**Consultation Response from Mike Hibbert,
KC Waste Strategy(Refuse & Recycling)**

2023/93464 Land at, Lingards Road, Slaithwaite, Huddersfield, HD7 5HY

Date Responded: 10/07/2024.

Responding Ref: WPS 24-038

SB HOMES
 LINCARDS ROAD
 PHASE 2 PLAN
 DRG SK 08
 JUNE 2024

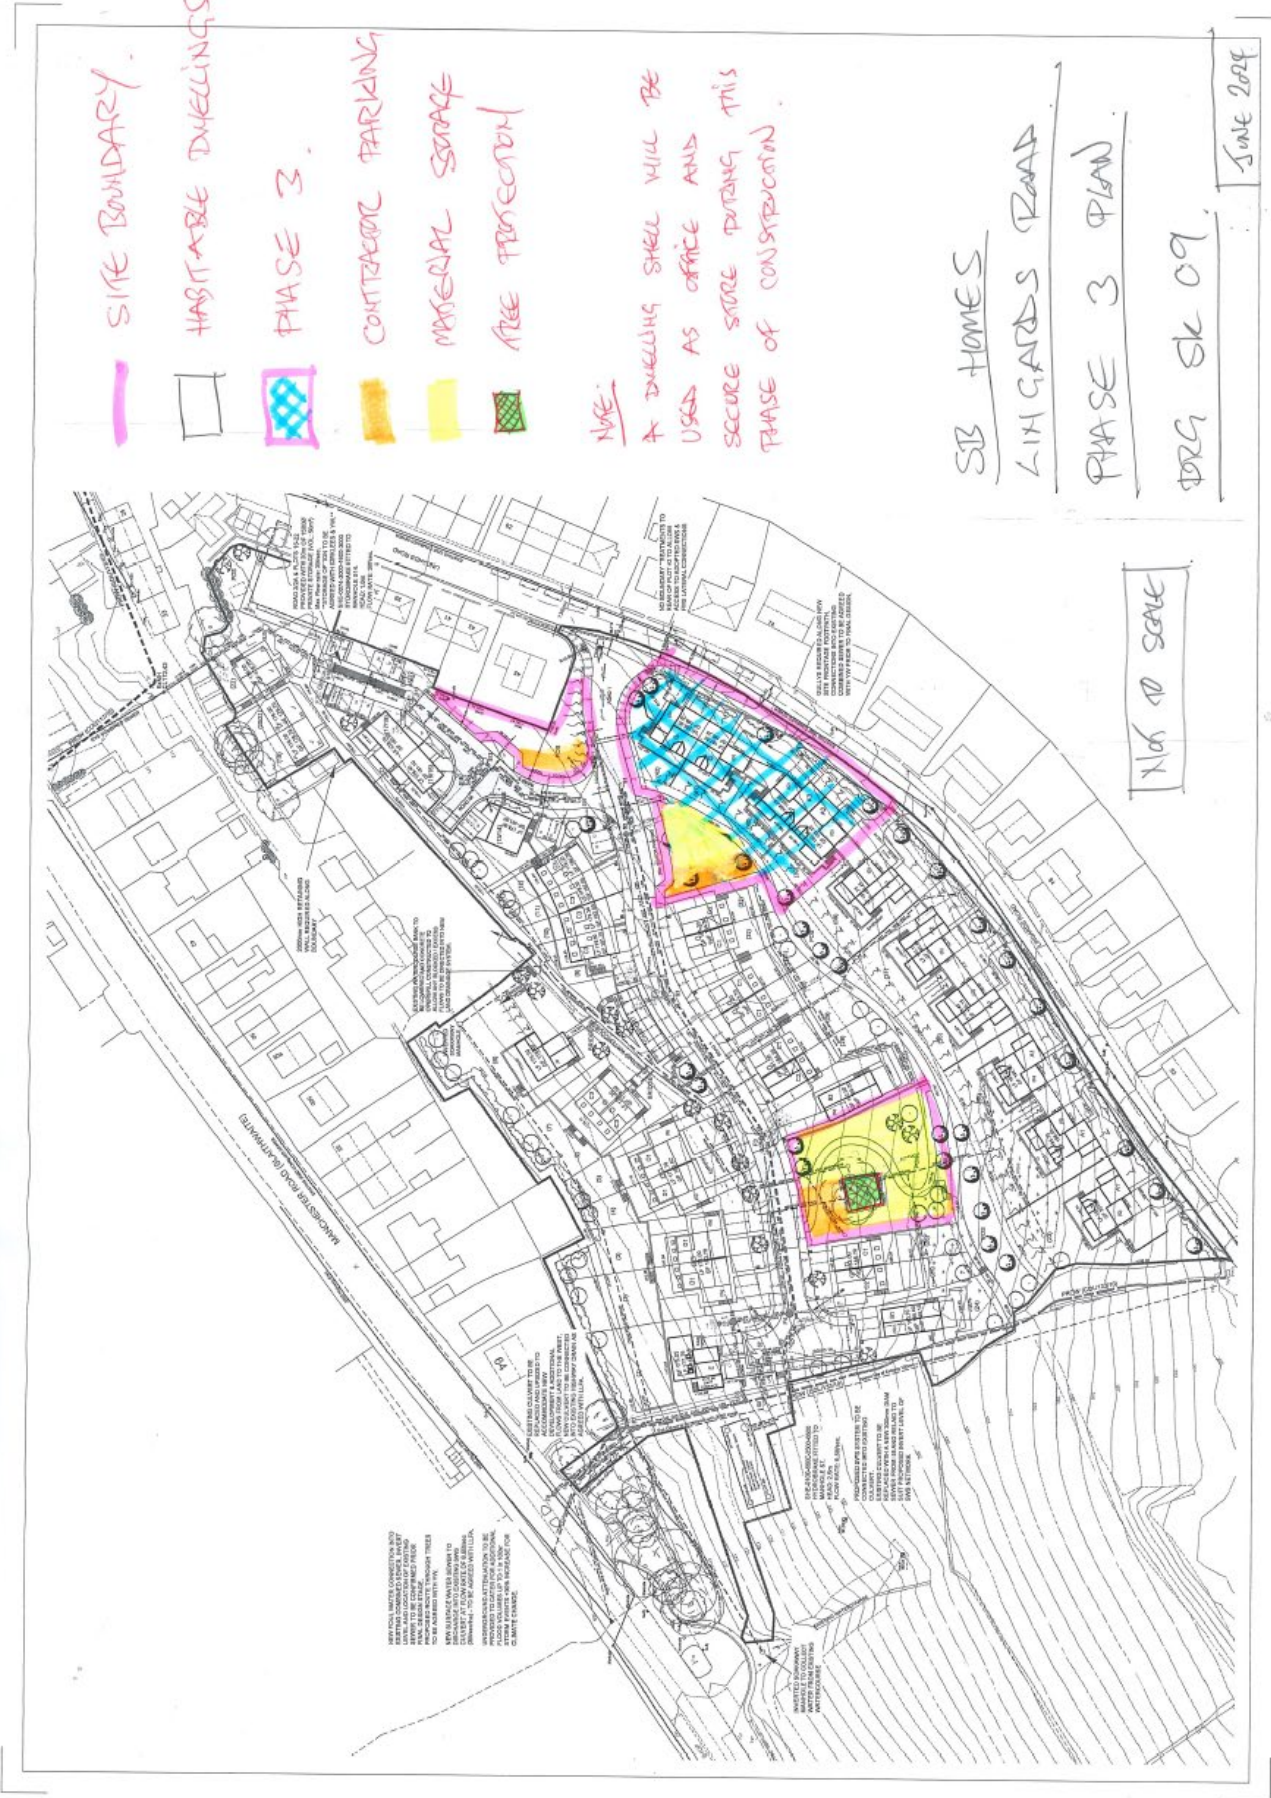
- Phase 1 Plan DRG SK02A
- Phase 2 Plan DRG SK08
- Phase 3 Plan DRG SK09

These Plans show the Phasing across the overall site and proposed sequence of collection.

- The Waste Collection Authority will not enter active construction sites with a Refuse Collection Vehicle (RCV). The rationale is to avoid damage to RCV's due to inadequate roadways, potential impact between RCV's or collection crew with contractors' plant/ delivery vehicles and remove the necessity for collection staff to undertake mandatory health and safety induction by the site manager.

- The WCA would appreciate the opportunity to meet on site with the site manager to discuss and confirm requirements in relation to access and waste collection points once residents start to occupy properties.
- For future phases, if an RCV is entering a site to service properties or a temporary waste store, then there must be demarcation such that a turning head is fenced off from the active construction site. Long reversing manoeuvres by RCV's is a recognised safety risk for both collection staff and members of the public and must be avoided.

Once a meeting has taken place at commencement of construction to establish on-site arrangements the WCA will be willing to confirm discharge of Condition 29.
